Application No: BR/129/21/OUT

Site Address: 26 Burnham Avenue Bognor Regis PO21 2JU

Description of Works: Outline application with all matters reserved for 10 new dwellings consisting of 1 No. 1 bed property, 8 No. 2 bed properties and 1 No. 4 bed property with associated services, landscaping, car parking & amenity (resubmission following BR/190/20/OUT).

EAST ELEVATION - BLOCK 1 (PROPOSED) 1:100

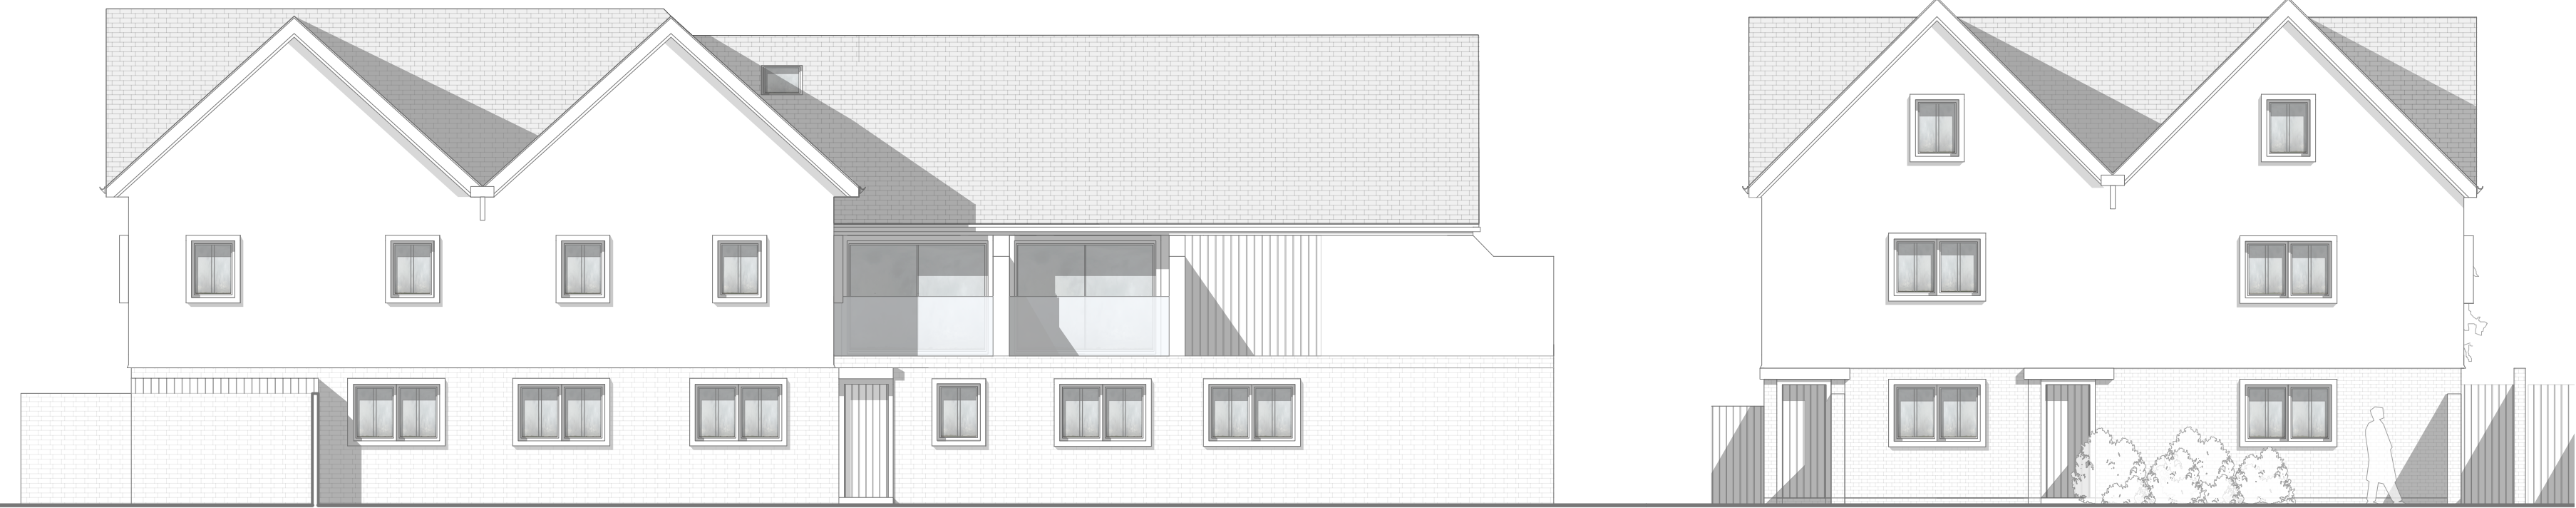
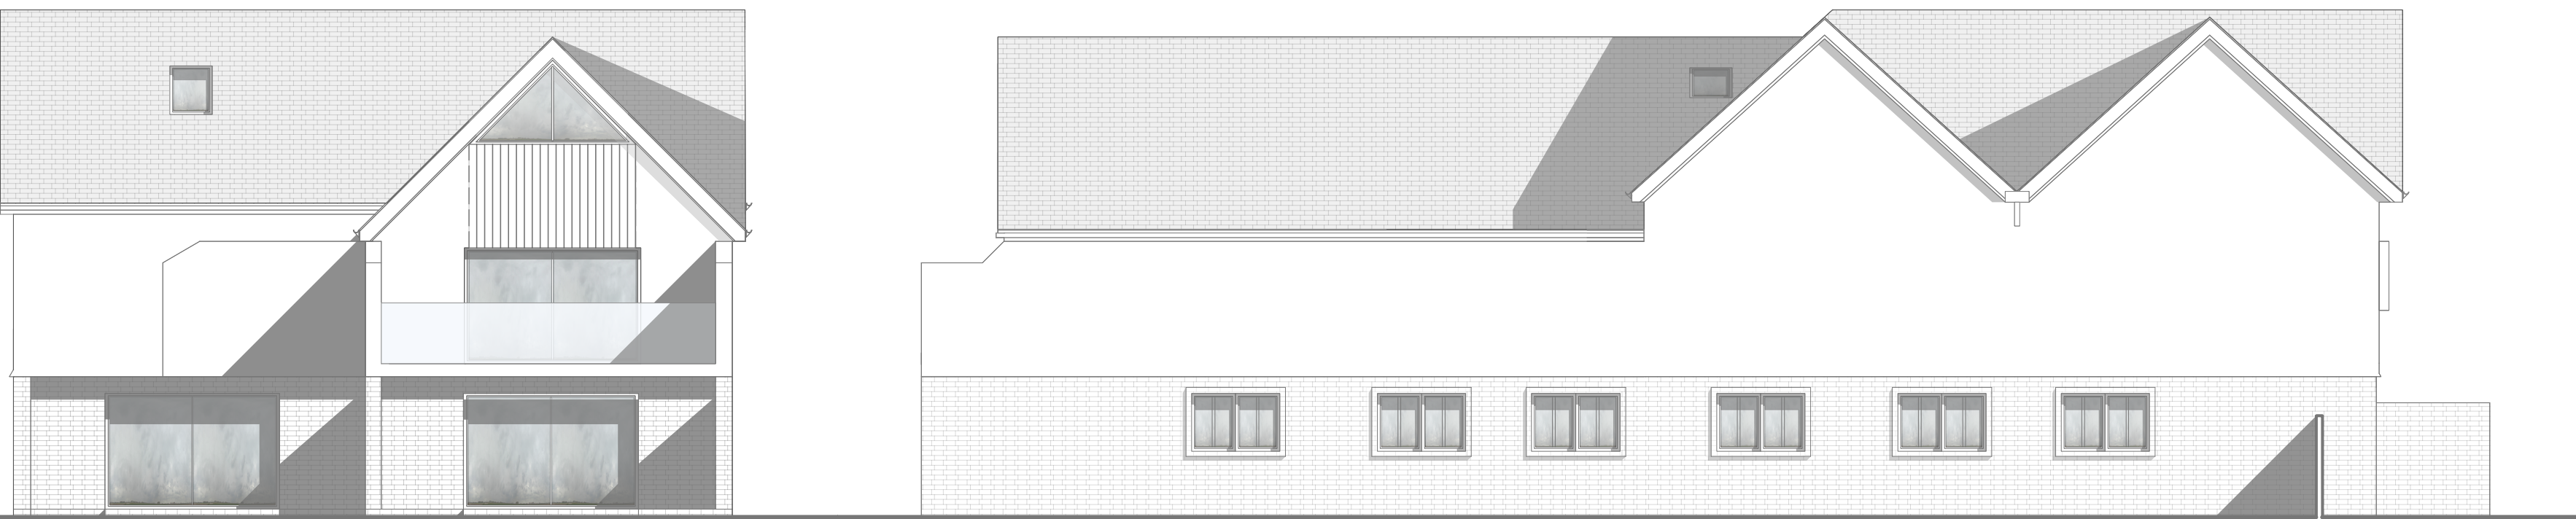
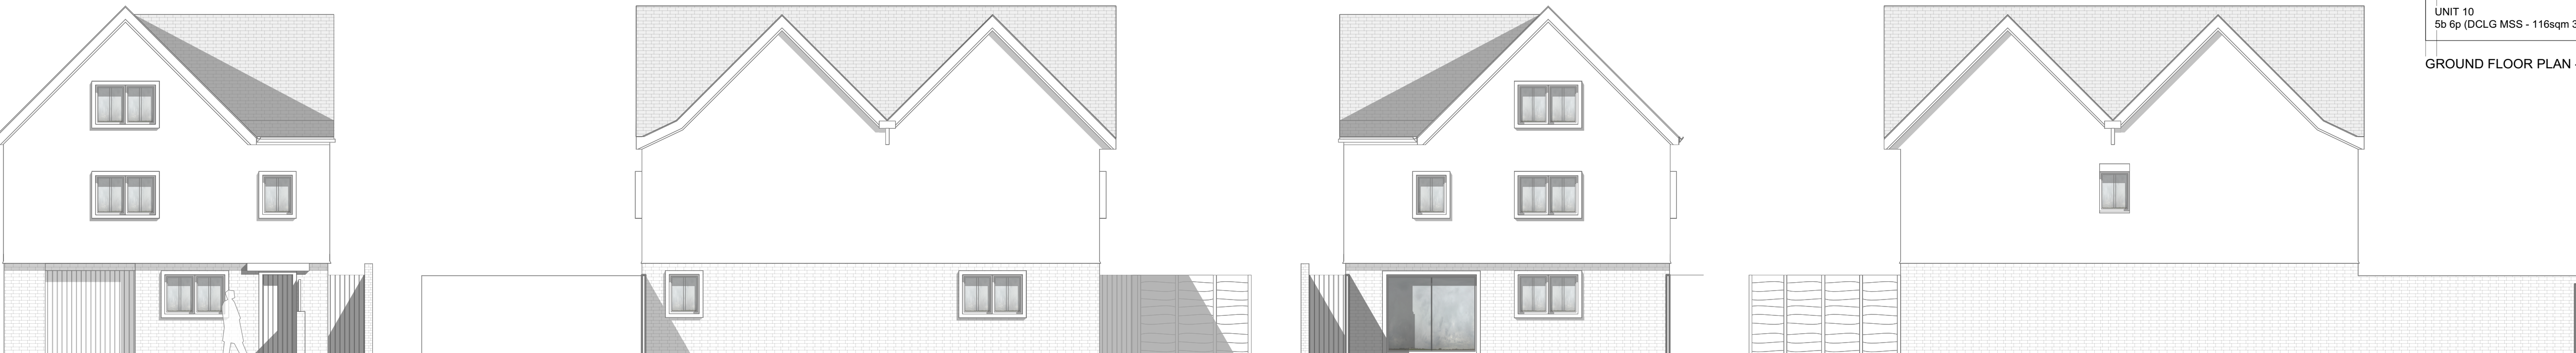
We require that a bat brick is integrated into the building onsite facing south/south westerly positioned 3-5m above ground.

We would like a bird box to be installed on the extension / and or tree within the garden of the property.
